KITTTITAS COUNTY COMMUNITY DEVELOPMENT SERVICES

June 9, 2017

Subject: PD-16-00001 & LP-17-00004 Carrier Heights PUD & Preliminary Plat Additional Information Required

SHEET CONTENTS
SITE PLAN

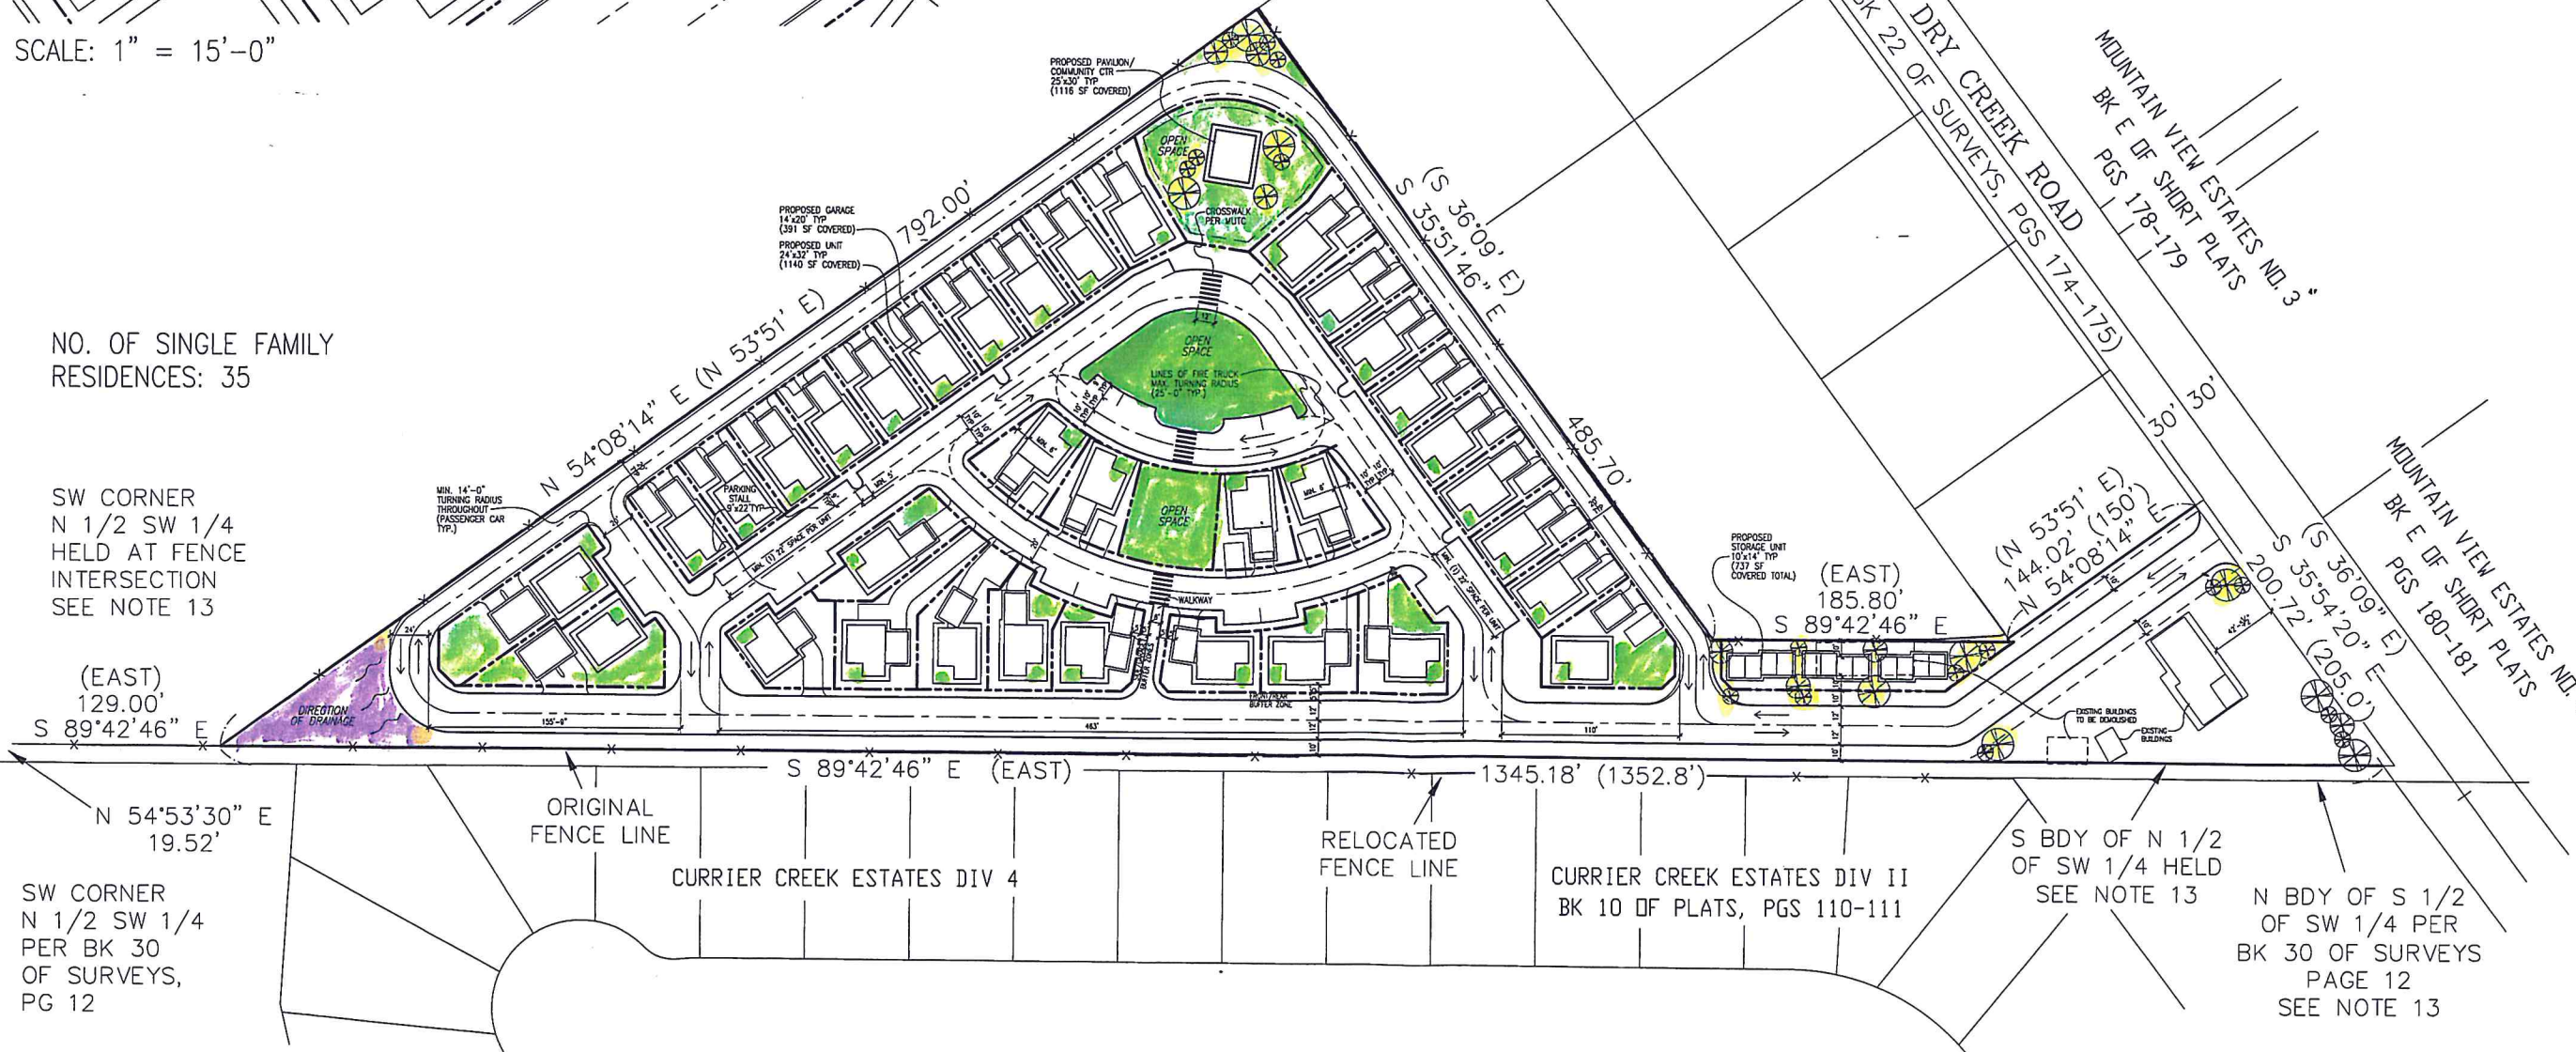
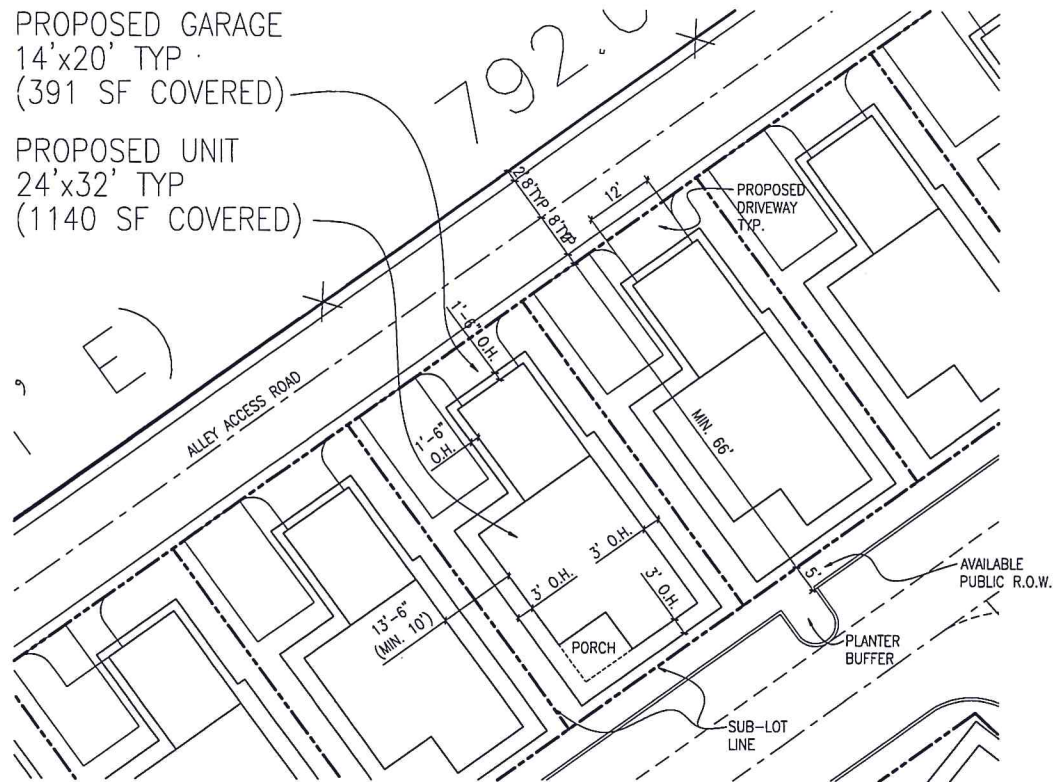
1. KCC 17.36.025 describes permitted density for Planned Unit Developments (PUD). An increase in density may be permitted, providing development rights are transferred and additional natural and social amenities are provided. According to the PUD application, no transfer of density is proposed. The application states that the total area of the property is

4.47 acres, which would not allow the proposed density without transfer of development rights. The plat application states that the total area of the property is 5.63 acres. Therefore, please revise the applications so that the correct acreage is shown, and describe how the proposal meets density requirements.

2. KCC 17.36.030 requires a preliminary development plan for the zone change application. KCC 16.12.020 requires preliminary plat drawings for the preliminary plat application. The preliminary development plan submitted with the PUD zone change application is not consistent with the preliminary plat drawings submitted with the preliminary plat application. Therefore, please submit consistent development plan and preliminary plat drawings.

3. KCC 17.36.030(4)(D) requires critical areas and natural features be shown on the preliminary development plan. According to the National Wetland Inventory, the site contains wetlands, which are not shown on the development plan. Please revise the preliminary development plan to show critical areas and natural features.

4. According to KCC 17.36.030(6), a phasing plan is required with identified timelines. The development plan shows phasing, but no explanation is provided. Therefore, please provide a phasing plan with required timelines.

8. KCC 16.12.020 requires preliminary plat drawings that include the following information:
 1. All preliminary plat drawings shall be submitted on eighteen by twenty-four inch sheets. When required by the county public works director, proposed road plans and profiles prepared by a licensed civil engineer shall be submitted on standard 22" x 36" sheets for review. The scale shall be 1" = 100' horizontal and 1" = 10' vertical, sheet one.

The preliminary plat application did not include preliminary plat drawings that include all of the information. Therefore, please submit preliminary plat drawings that include all of this information.

9. KCC 16.12.030(2) requires location, width, and type of all roads, streets, alleys, easements, and rights-of-way on and adjacent to the proposed subdivision to be shown on the preliminary plat. Therefore, please provide this information on the preliminary plat to the satisfaction of Kittitas County Public Works.

10. KCC 16.12.030(3) requires the location of all existing ditches apparent or of record, marshes, areas subject to flooding, and direction of all watercourses to be shown on the preliminary plat. Therefore, please submit a revised preliminary plat that includes this information.

11. According to KCC 16.12.030(6), the total acreage and total number of lots within the proposed subdivision shall be indicated on sheet one of the plat. Please submit a revised preliminary plat that includes total acreage and total number of lots.
